**From:** [REDACTED] <[REDACTED]@denbighshire.gov.uk>  
**Sent:** Tuesday, December 3, 2024 4:56 PM  
**To:** Prosiect Gwynt Alltraeth Mona | Mona Offshore Wind Project <[REDACTED]@Monaoffshorewind.com>  
**Cc:** Paul Mead [REDACTED] <[REDACTED]@denbighshire.gov.uk>; David Brown (X) [REDACTED] <[REDACTED]@arup.com>; Mike Jones Traffic [REDACTED] <[REDACTED]@denbighshire.gov.uk>  
**Subject:** MONA OFFSHORE WIND LTD: PLANNING INSPECTORATE REFERENCE: EN010137

I writing in relation to the Change 1(a and b): The amendment of the proposed Order limits to include an existing access track for temporary construction access during onshore site preparation works and a parcel of land to the west of the onshore substation for temporary construction access during onshore site preparation works and construction of the onshore substation and surrounding works. This involves the inclusion of two new plots of land (plots 11-197a and 11-197b) which would be subject to powers of temporary possession only.

Change 1a

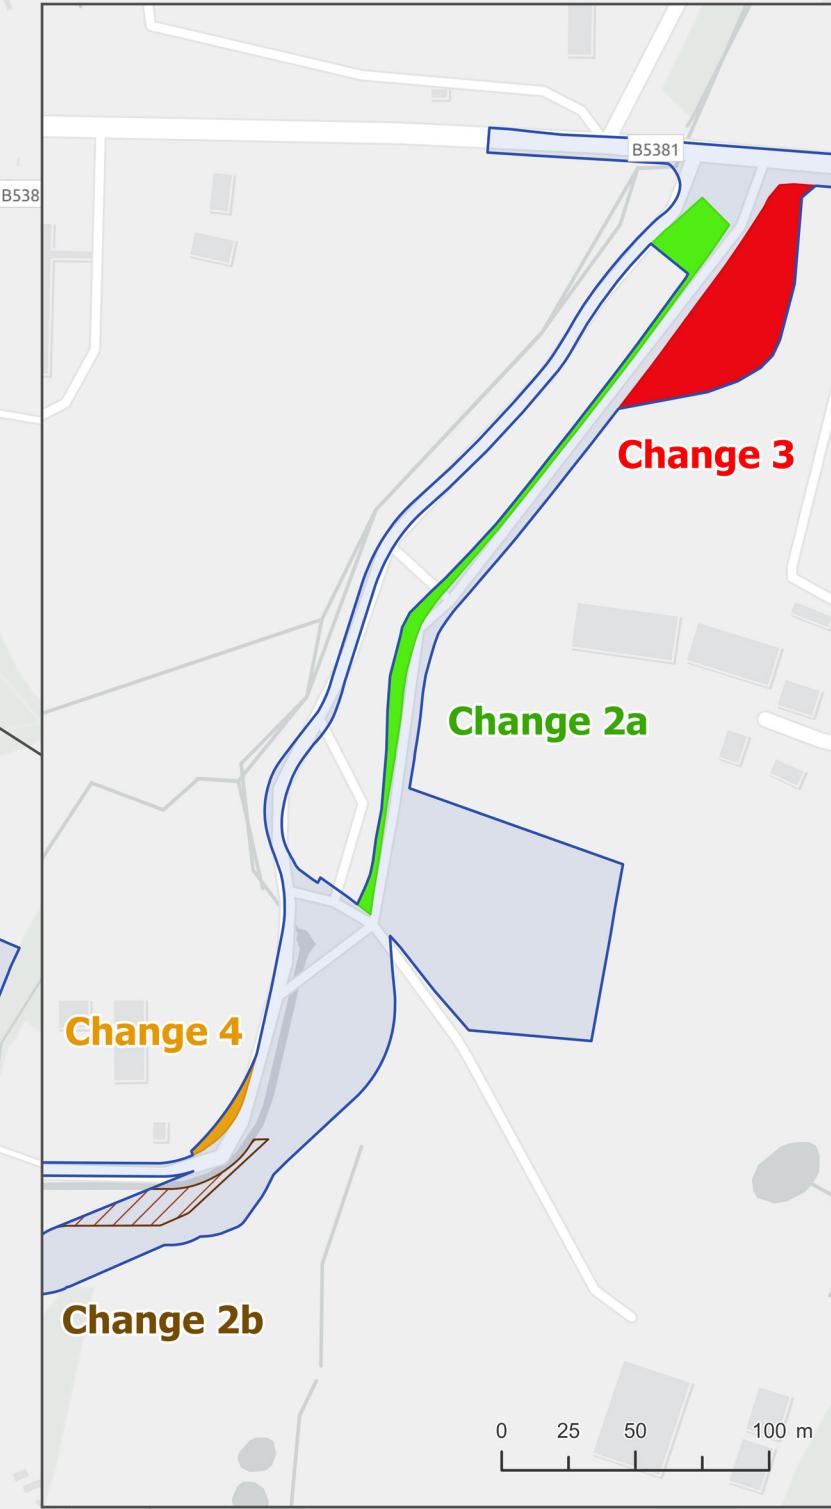
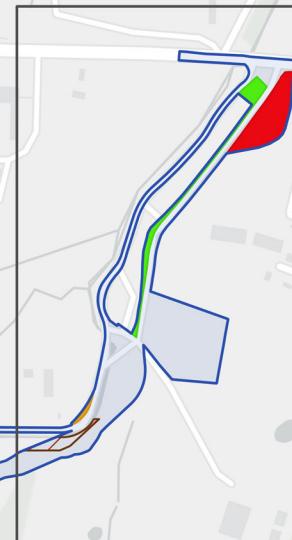
I have the following concerns in relation to the following on a road which according to our records is adopted highway.

- The junction visibility.
- The carriageway width.
- The condition of the road.
- The drainage/ditches.
- The vehicle numbers and size proposed to use this road
